PLANNING CONSULTATION RESPONSE

Application No	2026/0341
Proposal	Change of use from Doctors Surgery (Use Class E(e)) to Respite Unit Residential Institution (Use Class C2)
Address	Galtee More Residential Home, 164 Doncaster Road, Barnsley, S70 1UD
Date of Consultation Reply	29/07/2026
Consultee	Katie Lawrence, Planning Ecologist

TITLE  
 PROPOSED ELEVATIONS

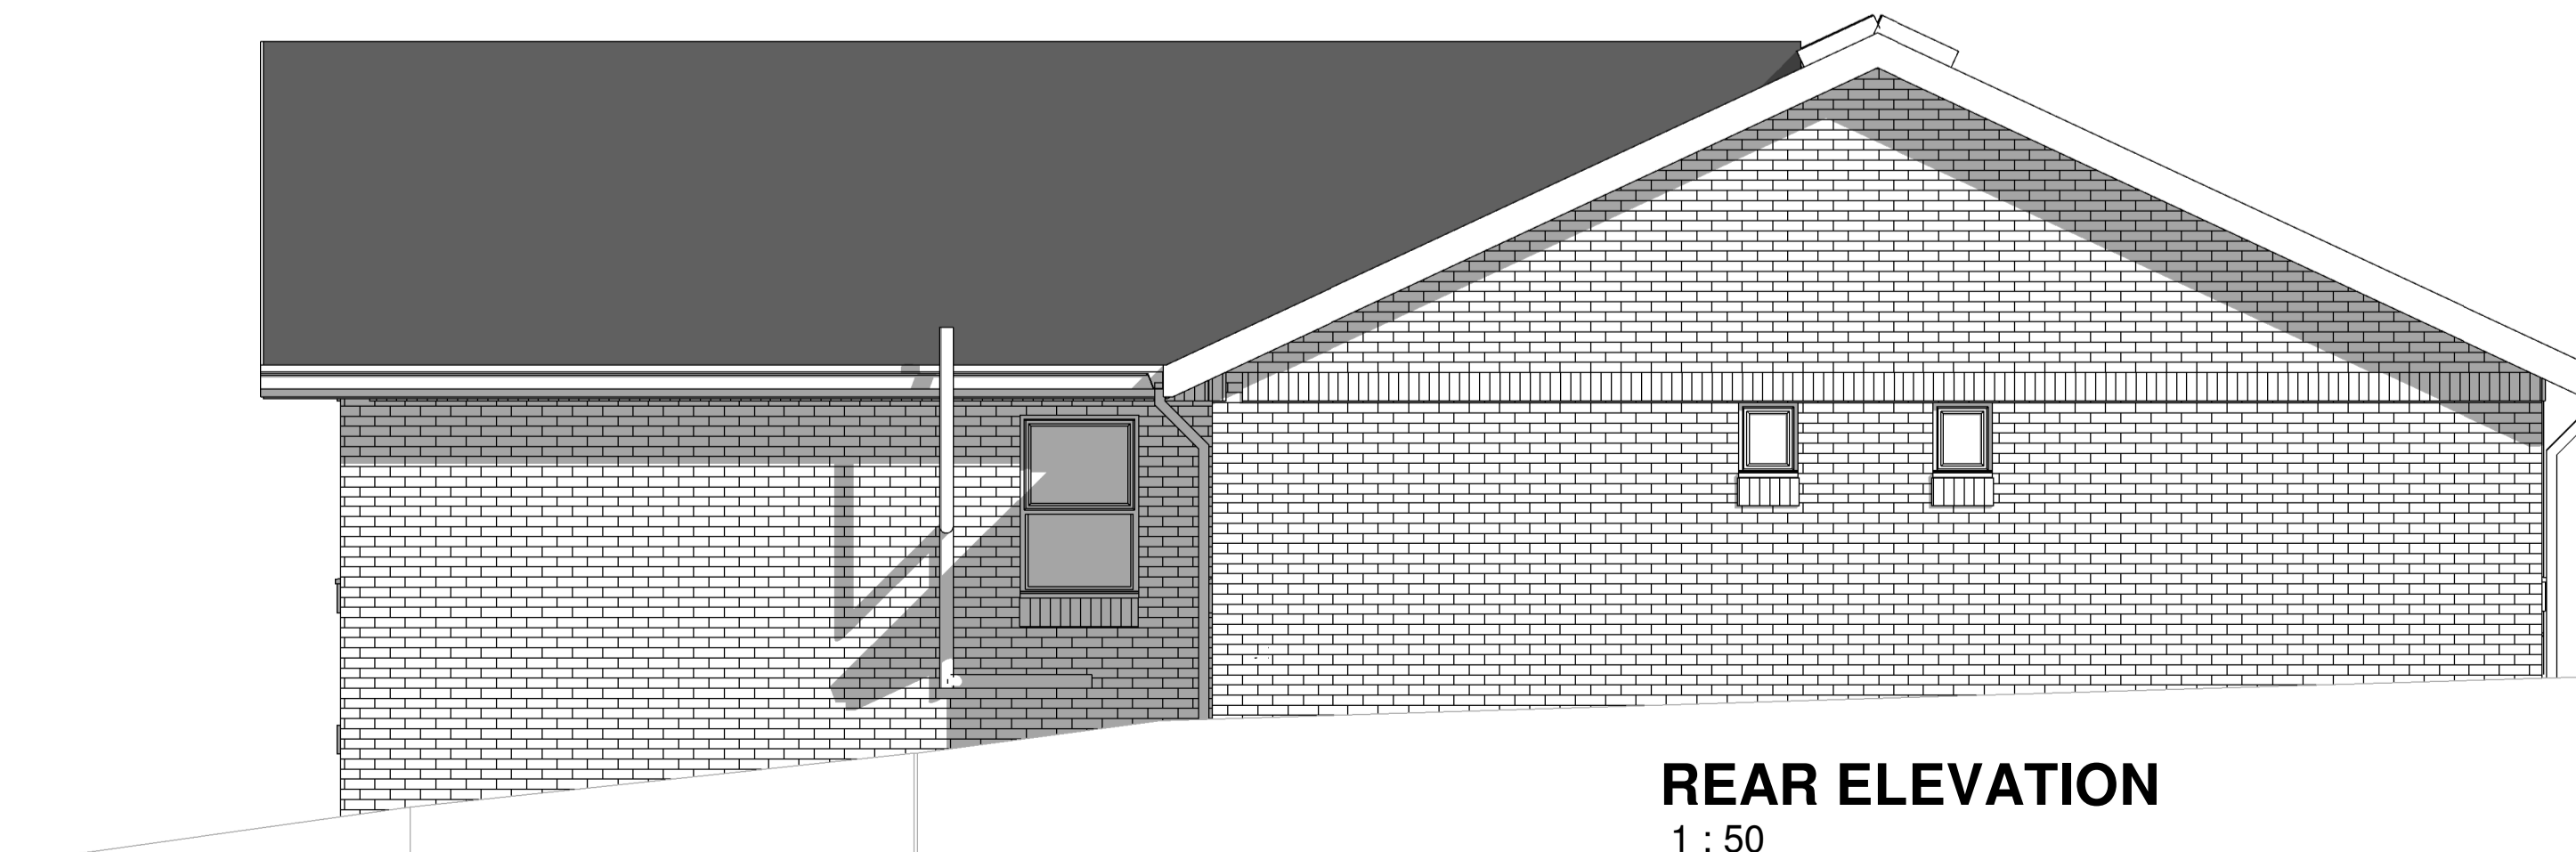
- The applicant has confirmed that the hedgerow/shrubs associated with an existing fence on site won't be affected by the proposed works and on this basis, I accept that the development meets the de minimis exemption in relation to Biodiversity Net Gain.
- The proposed elevations plan has been updated to indicate the location and type of bat and bird boxes to be incorporated on the existing building. This is welcomed and can be secured by a planning condition.

The development shall be completed in strict accordance with the proposed elevations plan indicating the location and type of bat and bird boxes to be installed. The proposals shall be implemented in full and thereafter permanently maintained for the stated purposes of biodiversity conservation. Photographic evidence should be submitted to the LPA to show the incorporation of these features once installed.
